CITY OF ALBUQUERQUE

August 27, 2024

Re: Dunkin
10631 Unser NW
Traffic Circulation Layout
Engineer's/Architect's Stamp xx-xx-xx (A11D017A)

Based upon the information provided in your submittal received 8/23/24, the above referenced plan cannot be approved for Building Permit until the following comments are addressed:

4	DETAIL-ACCESSIBLE PAVEMENT SYMBOL
C7.2	NOT TO SCALE

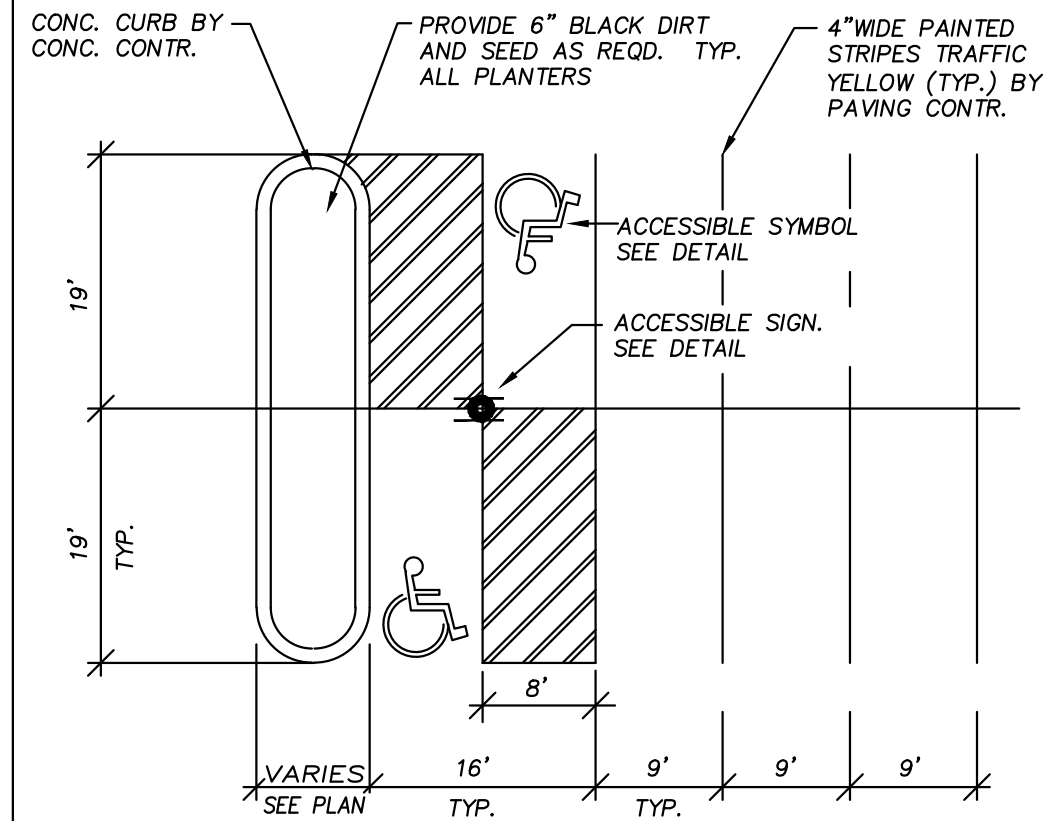
8. The ADA access aisles shall have the words **"NO PARKING"** in capital letters, each of which shall be at least one foot high and at least two inches wide, placed at the rear of the parking space so as to be close to where an adjacent vehicle's rear tire would be placed. (66-1-4.1.B NMSA 1978)

5	TYP. 90° PARKING
C7.2	NOT TO SCALE

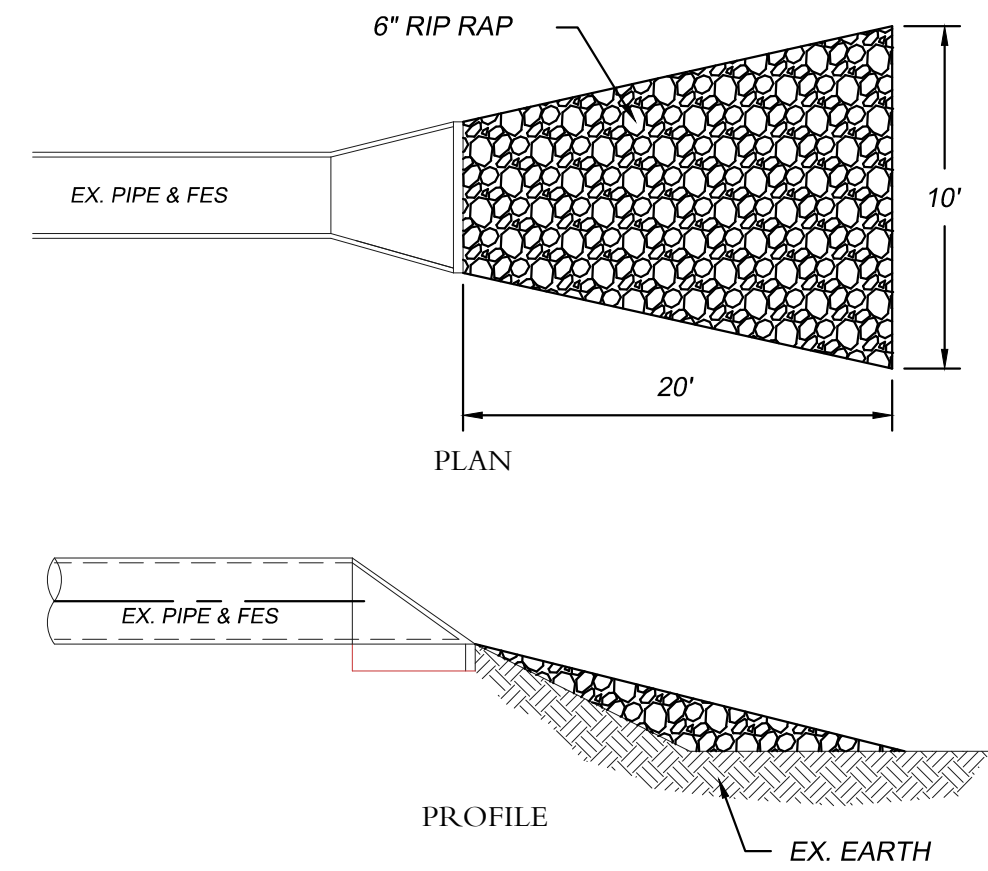
1. Please show a vicinity map showing the location of the development in relation to streets and well known landmarks on site plan C1.1.
2. The traffic circulation layout must be stamped, signed, and dated by an engineer or architect licensed in the state of New Mexico.
3. Show the North Arrow and scale of site plan, a scale of 1"=20' is recommended for sites less than 5 acres.
4. Identify the right of way width, medians, curb cuts, and street widths on Unser Blvd.
5. The minimum parking stall depth is 18.7 ft

22. ADA parking width is 8.5 ft

8 ACCESSIBLE SIGN  
C7.2 NOT TO SCALE

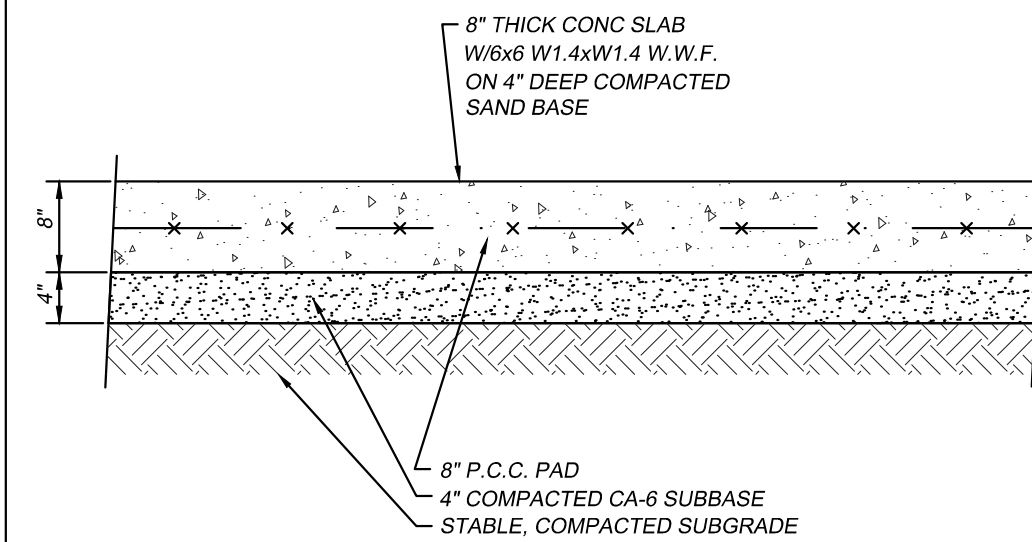
7. The ADA accessible parking sign must have the required language per 66-7-352.4C NMSA 1978 **"Violators Are Subject to a Fine and/or Towing."** Please call out detail and location of signs.
